CITY OF PORTLAND

Permit Number 051512

has permission to Addition & Renovations to the existing structure. 2,000 sq ft addition

AT 143 SUMMIT ST. City of Portland 396 C019001

1 SECTION THROUGH NEW STAIR ADDITION
1/2" = 1'-0"

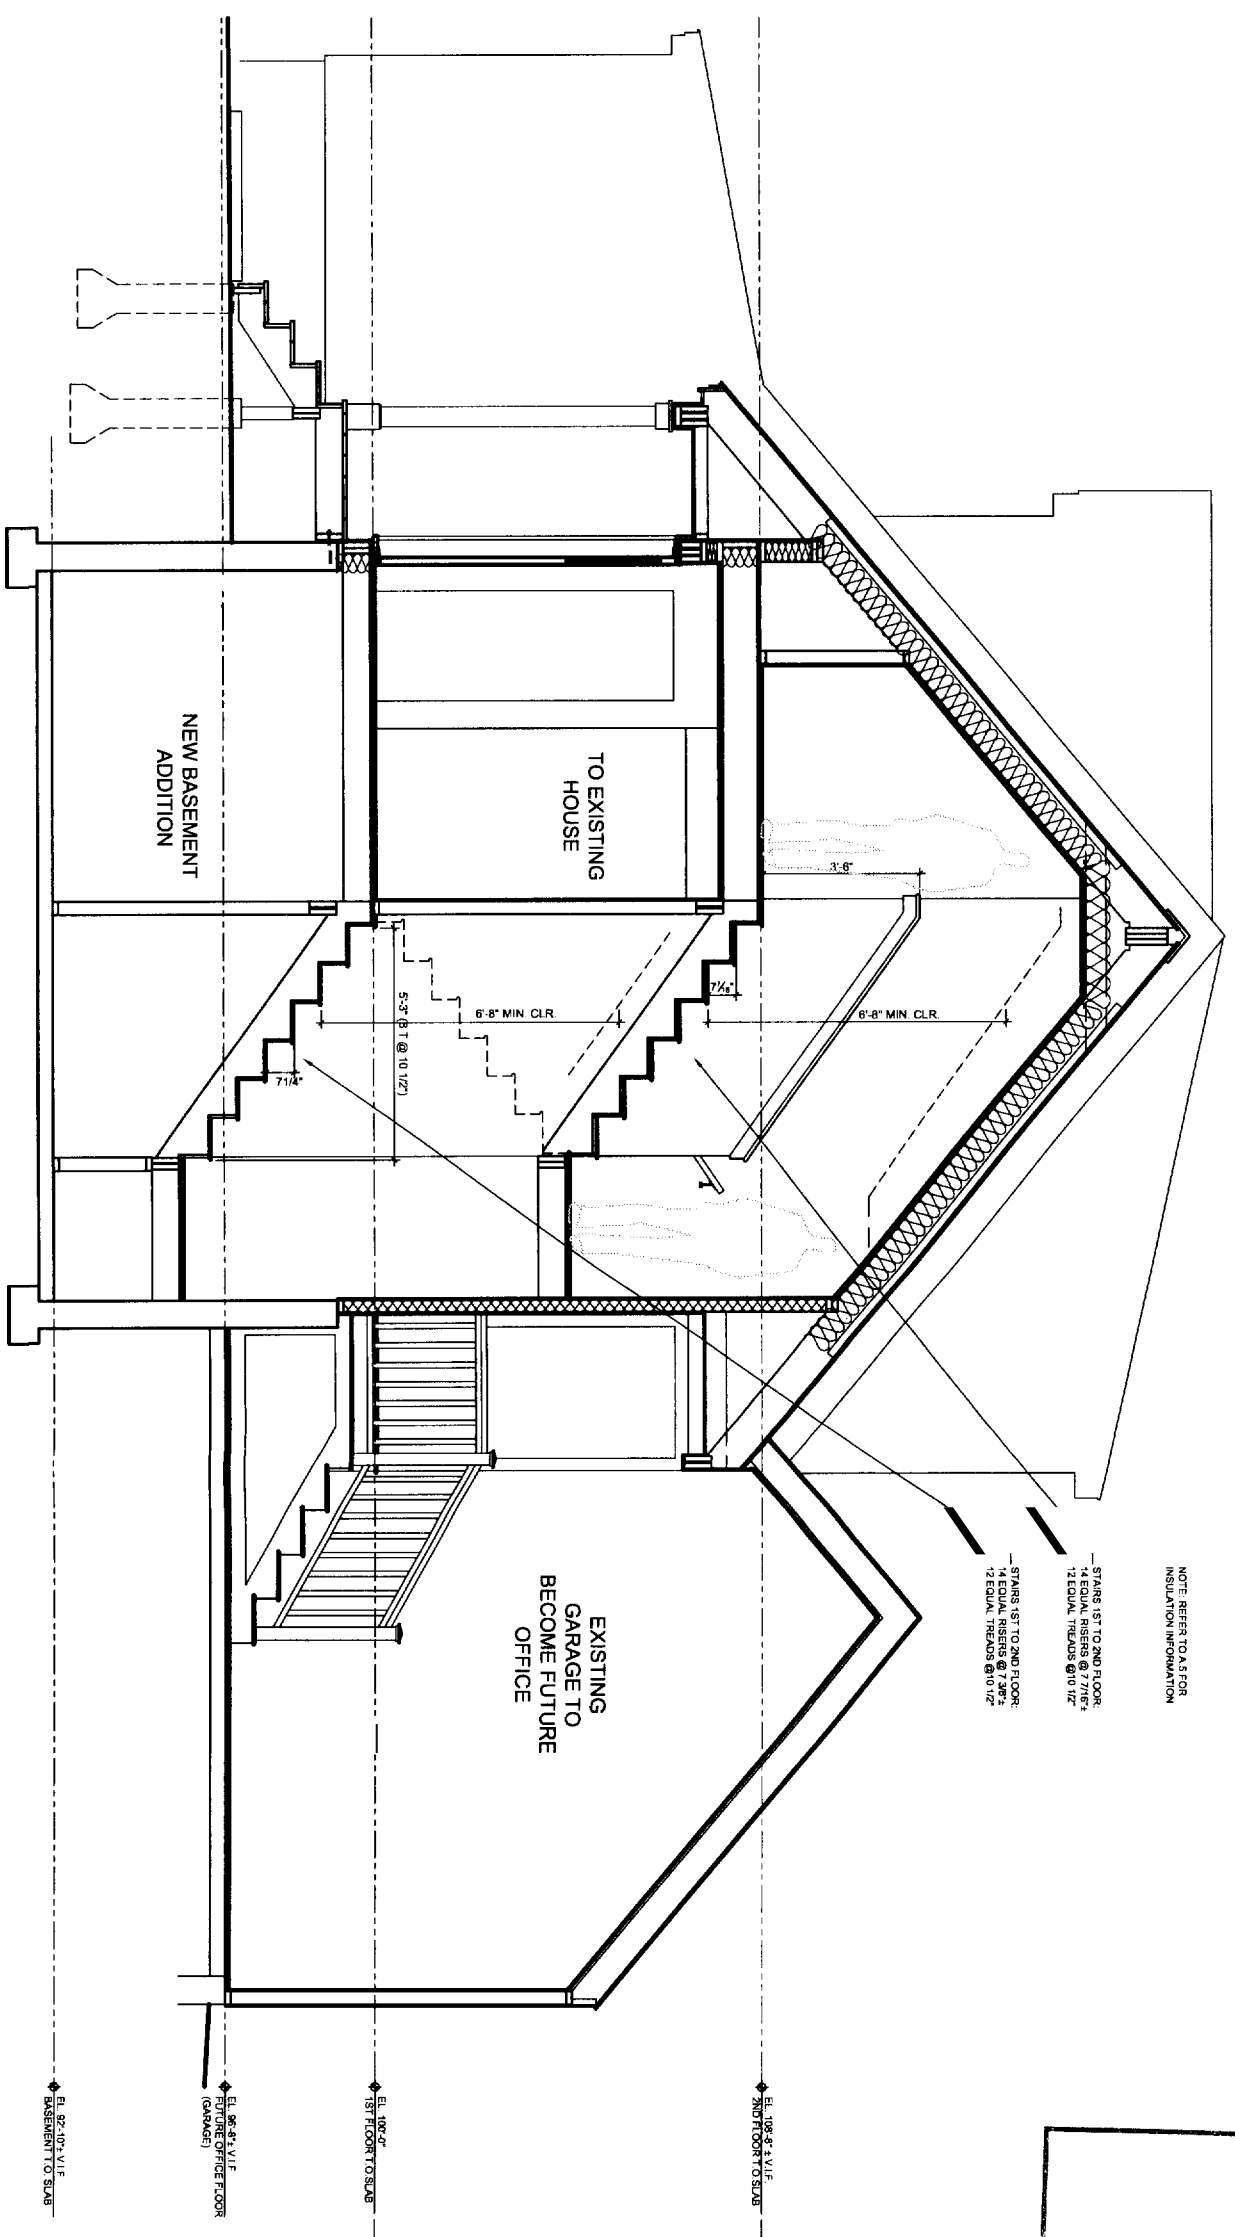
Factor Fenestration		
Type of Heating System		
Means of Egress (Sec R311 & R312)		
Basement		
Number of Stairways 4		
Interior 1		
Exterior 3		
Treads and Risers (Section R311.5.3)	inter - ok	
Width (Section R311.5.1)	need all	details on exterior stairs OK
Headroom (Section R311.5.2)		
Guardrails and Handrails (Section R312 & R311.5.6 - R311.5.6.3)	not shown	
Smoke Detectors (Section R313) Location and type/Interconnected	not shown	
Dwelling Unit Separation (Section R317) and IBC - 2003 (Section 1207)	N/A	
Deck Construction (Section R502.2.1)	future decks?	OK

PROJECT NO: 055511
ISSUED: 11/18/05
DRAWN BY: CHB
CHECKED BY: ...
SHEET TITLE:
1ST FLOOR FRAMING
2ND FLOOR FRAMING

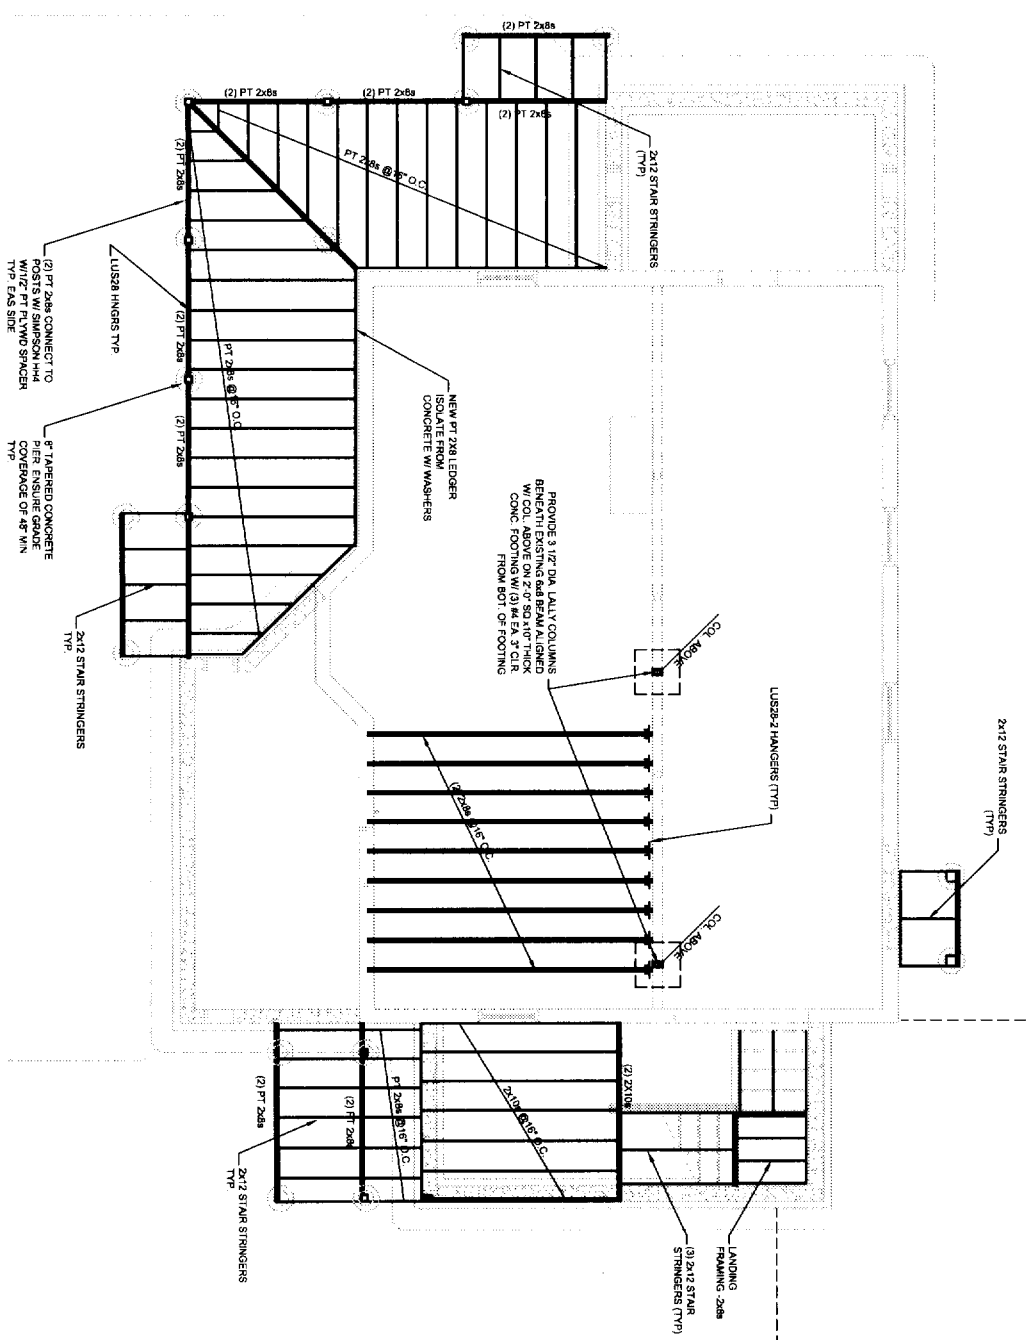
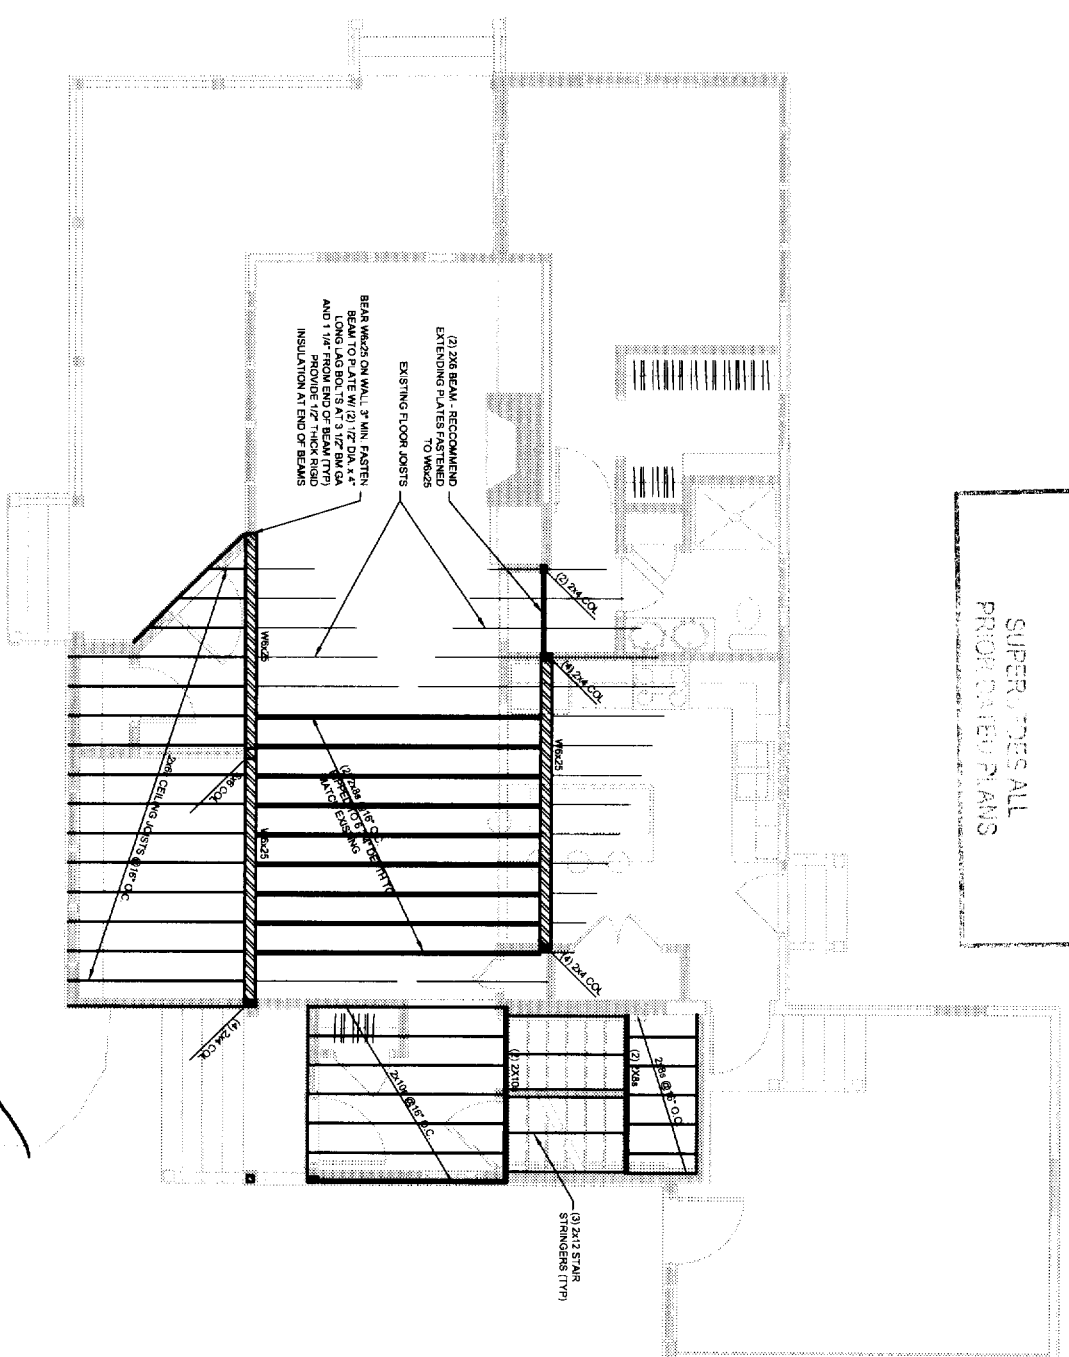
Pitch, Span, Spacing & Dimension (Table R802.5.1(1) - R 802.5.1(8))	OK	
Roof Rafter, Framing & Connections (Section R802.3 & R802.3.1)	Not shown	OK
Sheathing; Floor, Wall and roof (Table R503.2.1.1(1))	Per IRC	
Fastener Schedule (Table R602.3(1) & (2))		
Private Garage (Section R309) Living Space? (Above or beside)		
Fire separation (Section R309.1)	N/A	
Opening Protection (Section R309.1)	Not shown in master suite - OK	
Emergency Escape and Rescue Openings (Section R310)	OK	
Roof Covering (Chapter 9)	Need in stair window	
Safety Glazing (Section R308)	Not shown - size	
Attic Access (Section R807)	"	existing
Chimney Clearances/Fire Blocking (Chap. 10)	Not shown	
Header Schedule (Section 502.5(1) & (2))	Not shown	
Energy Efficiency (N1101.2.1) R-Factors of Walls, Floors, Ceilings, Building Envelope, U-	Not shown
